KIRKLEES METROPOLITAN COUNCIL INVESTMENT & REGENERATION SERVICE

DELEGATED DECISION TO DETERMINE PLANNING APPLICATIONS

Reference No:	2026/62/90571/W
Site Address:	Pavement o/s, Utilita, Ramsden Street, Huddersfield, HD1 2BQ
Description:	Installation of 1 BT Street Hub, incorporating 2 digital 75inch LCD advert screens, and associated BT Phone Kiosk removal (within a Conservation Area)
Recommending Officer:	John Holmes

DECISION - REFUSED

Drawing Title
SITE LOCATION MAPS

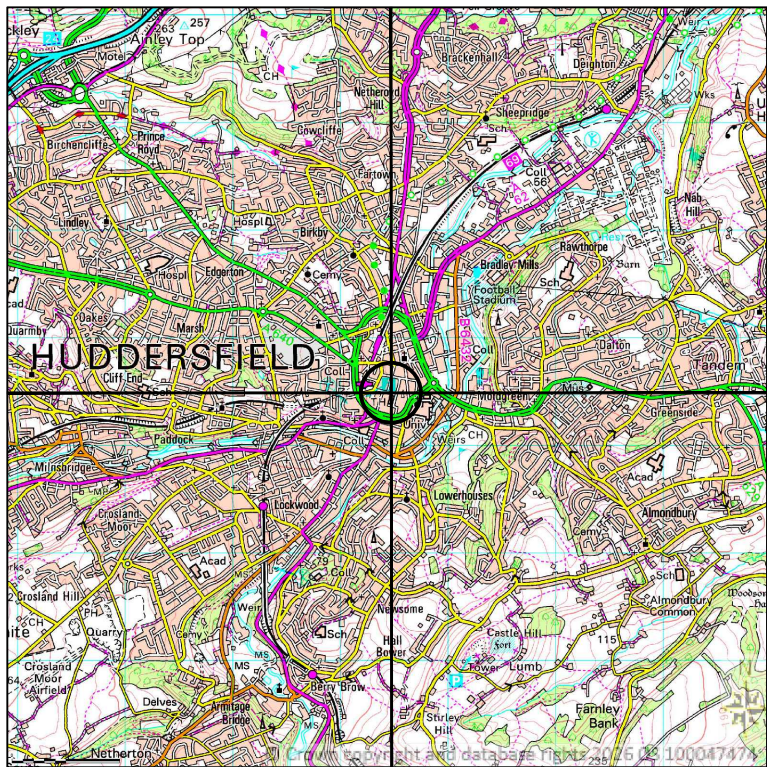
Clarification Note: Submitted plan (ref 001RevA) includes two site location plans at scale 1:1250 which show different sites. This application is assessed on the basis of the plan (E414438N416461) as this relates to the site with the same address upon the submitted form.

Clarification Note: Submitted plan (ref 001RevA) includes two site location plans at scale 1:1250 which show different sites. This application is assessed on the basis of the top plan (E414438N416461) as this relates to the site with the same address upon the submitted form.

Drg Status PLANNING				
Cell No. & Name HUD-09				
Site Name & Address Pavement o/s Utilita, Ramsden Street, Huddersfield, HD1 2BQ				
Drawing Title EXISTING AND PROPOSED ELEVATIONS				
Scale 1:50		Date 23/02/2026		
Drawn By PTM		Checked By ABH		
Drawing Number 003				Revision A

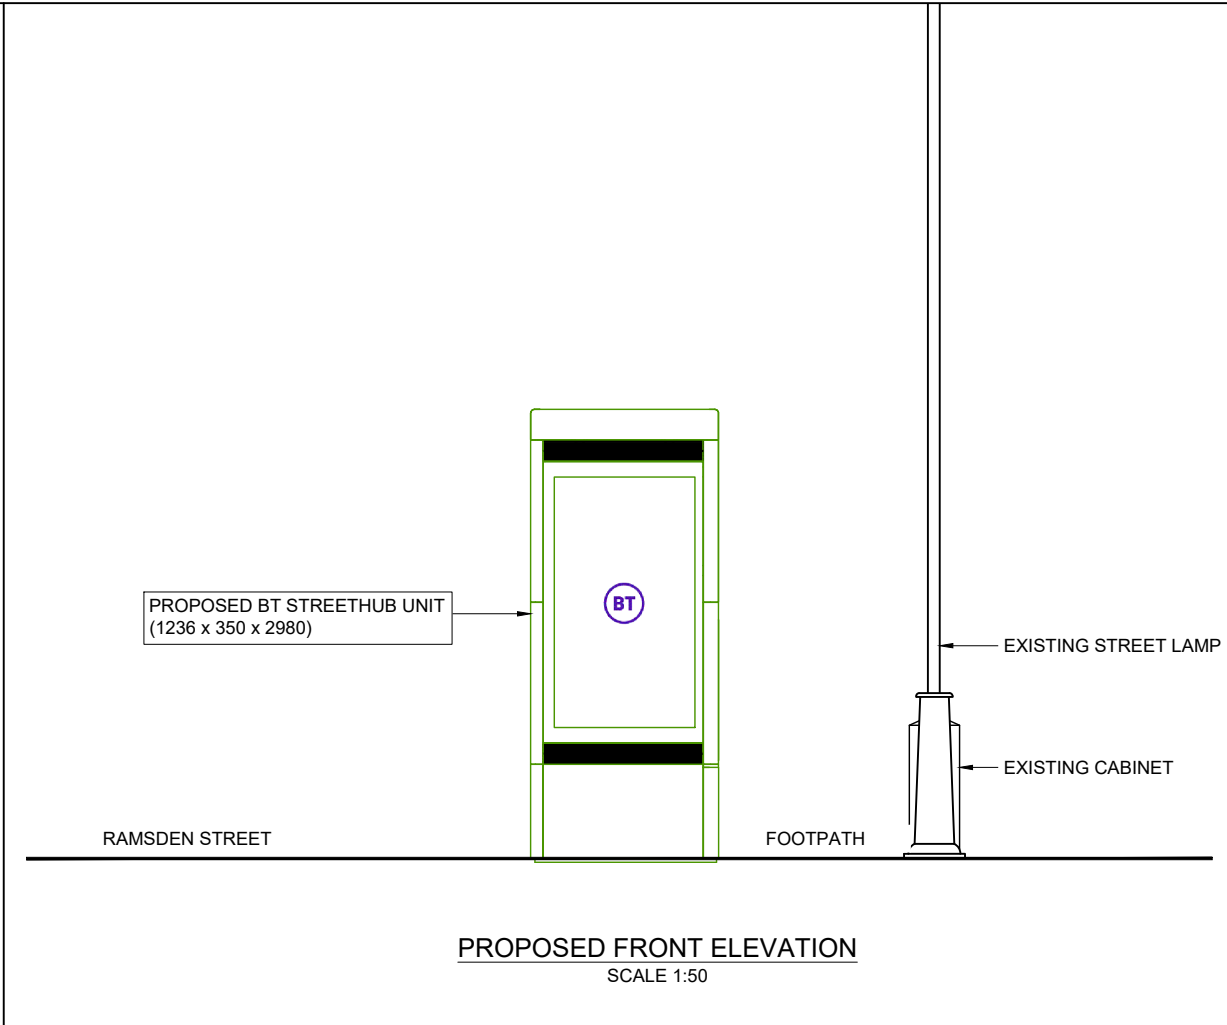
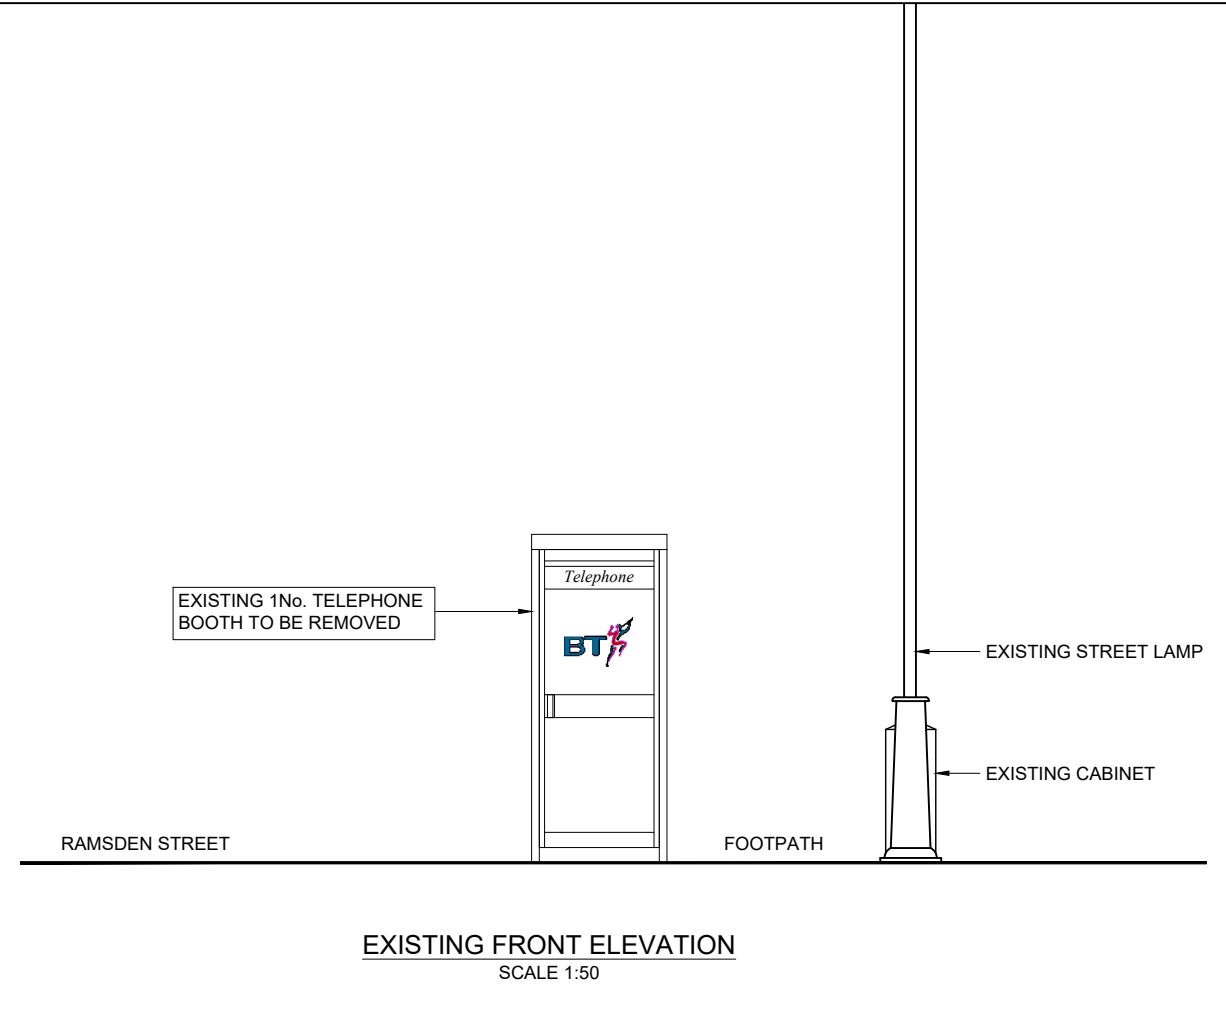
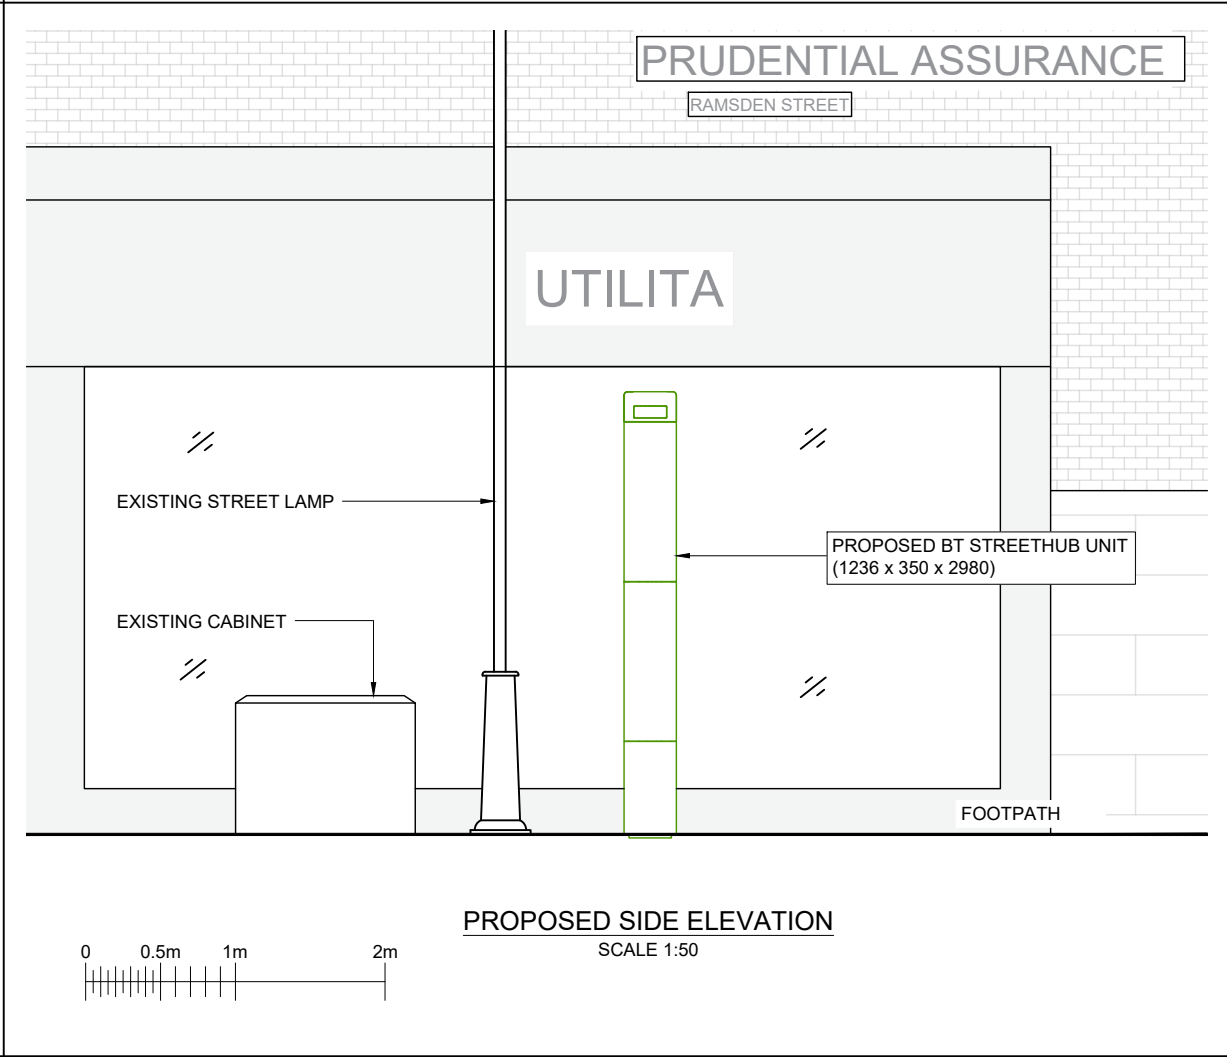
Thus, as well as being viewed as part of the setting of No.71, the hub would also be viewed in the setting of Huddersfield Town Hall, Queensgate Market and No.62 New Street. The proposed Street Hub would be a maximum height of ~3m high and would be highly visible within the street scene as it is sited in a prominent location on the footway. This prominence would be compounded by the advertising display on each side of being internally illuminated. The display of illuminated advertisements would in general be assessed separately, under an application for consent to display an advertisement. In this instance, however, the display screens are an integral part of the development under consideration. The likely visual impact of the screens and any advertisements they are likely to carry must therefore be assessed as part of this application so that the proposal's impact on visual amenity can be fully appreciated.

The removal of a single phone box would be a modest enhancement to the Conservation Area and the wider Town Centre. However, the introduction of the proposed Street Hub and its display panels would add further illuminated street clutter which would, especially in the context of already existing digital display screens, detract from the character of the area and cause cumulative harm. It would thereby conflict with both Huddersfield Blueprint initiatives mentioned above.

The proposed Street Hub would include illuminated screens on both sides. These are an integral part of the development under consideration, as set out in paragraph 2.2 of the Planning Supporting Statement. The proposed Street Hub and digital display screens, owing to their scale, prominent siting, means of illumination and the presence of other similar installations in the immediate vicinity, would be a visually intrusive feature that would cause harm to the visual amenities of the locality and less than substantial harm to the significance of the Huddersfield Town Centre Conservation Area as well as the nearby Grade II listed buildings of 71 New Street, Huddersfield Town Hall, Queensgate Market and 62 New Street and their setting. Having regard to the cumulative impact of similar installations already in existence, including on Ramsden Street, High Street and New Street, the proposal would add further illuminated street clutter which would detract from the character of the wider Town Centre, and would prejudice the aims of the Huddersfield Blueprint, a ten-year regeneration initiative to rejuvenate the town centre and enhance public spaces. The harm caused to designated heritage assets would be less than substantial and the public benefits associated with the proposed development would not outweigh the harm caused. The proposal is therefore contrary to Policies LP17 (a), LP24(a), and LP35 of the Kirklees Local Plan, Chapters 12 and 16 of the NPPF and Sections 66 and 72 of the Planning (Listed Buildings and Conservation Areas) Act 1990.
